# London Luton Airport Expansion

**8.127 Applicant's Response to Deadline 5 Submissions**

**Appendix E - National Highways**

Document Ref: TR020001/APP/8.127

Figure 8 - An extract from the intervention's drawing M1_J10_SB_Mer_Op2

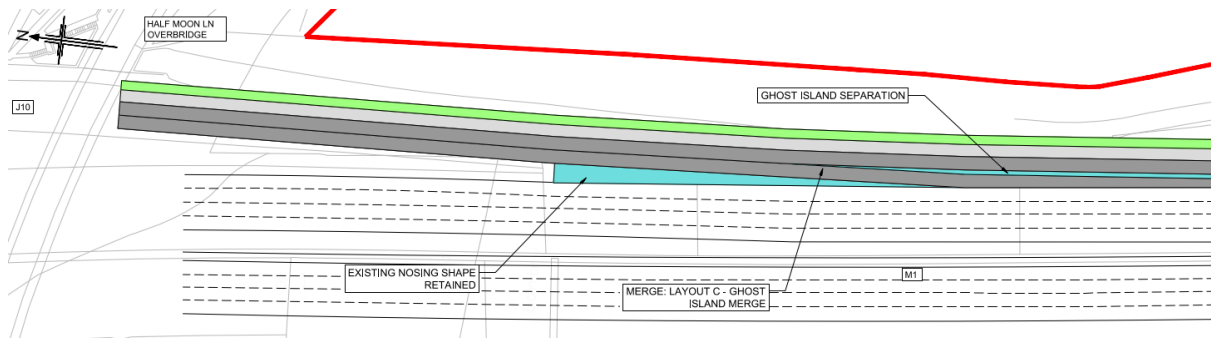
I.D	Topic	Deadline 5 submission (Verbatim)	Luton Rising's Response
4	Surface Access	<p>National Highways is concerned about residual congestion and safety issues on the M1 junction 10 southbound slip roads and their interaction with the mainline carriageway following the implementation of the Applicant's proposed mitigation works associated with airport growth. Two interventions have been identified that would increase the capacity and journey reliability of M1 Junction 10 in 2043, thereby enabling with maximum airport growth with improved SRN performance.</p> <p>The interventions would deliver capacity increases in the Luton Rising VISSIM model with higher capacity DMRB CD 122 merge/ diverge layouts proposed than with the proposed Luton Rising layout.</p>	As ID3 above.
5	Surface Access	<p>Based on the VISSIM testing, it is clear that Intervention 1 could provide a substantial benefit to network operation by removing the lane drop on the northbound carriageway on the M1 and enabling Junction 10 to accommodate the released traffic and demand from the Luton Rising airport expansion.</p>	<p>As noted above, the Applicant considers the impacts of the Proposed Development have been mitigated. The Applicant also notes that the Rule 9 modelling is showing a substantial reduction in demands at M1 Junction 10.</p> <p>Baseline congestion should be a matter for National Highways as the responsible highway authority to address.</p>

6	Surface Access	<p>Due to the limitations of the VISSIM model, it is difficult to draw definite conclusions on the performance of Intervention 2. However, a deliverable solution to improve capacity at the Junction 10 southbound merge has been identified. This capacity upgrade leads to a slight improvement in network performance in the VISSIM model, with the model locking up later, allowing a longer period of free flowing traffic on the SRN. It is advised that the calibration of the M1 in this area of the model should be revisited so that the option can be fully assessed.</p>	<p>We would disagree on the status of the VISSIM model. This has been developed through extensive consultation with the respective highway authorities.</p> <p>Nevertheless, and as noted above, the Rule 9 modelling is showing a substantial reduction in demands at M1 Junction 10 and the updated modelling is likely to show significant reductions in associated impacts.</p>

7	Surface Access	<p>Following consideration of changes in forecast flows on the two slip roads arising from the post-covid demand work undertaken by the Applicant's consultants, National Highways considers that the mitigation to the southbound on slip will be required in advance of Phase 2a (at a point to be determined between phases 1 and 2a). The northbound slip will require additional mitigation in advance of Phase 2b. National Highways considers that a Grampian requirement will need to be in place for each of these mitigation phases and suitable drafting was included in National Highways' deadline 4 submission.</p>	<p>National Highway position is noted.</p> <p>As set out above, the Rule 9 modelling is showing a substantial reduction in demands at M1 Junction 10 and that any requirements for additional mitigation are premature. The applicant has also explained that the development already proposes mitigation to the southbound on-slip and that a significant proportion of the impact is associated with background traffic and not the development which should be a matter for National Highways to address as the responsible highway authority. The applicant believes that the Airport contribution of impact is mitigated.</p>
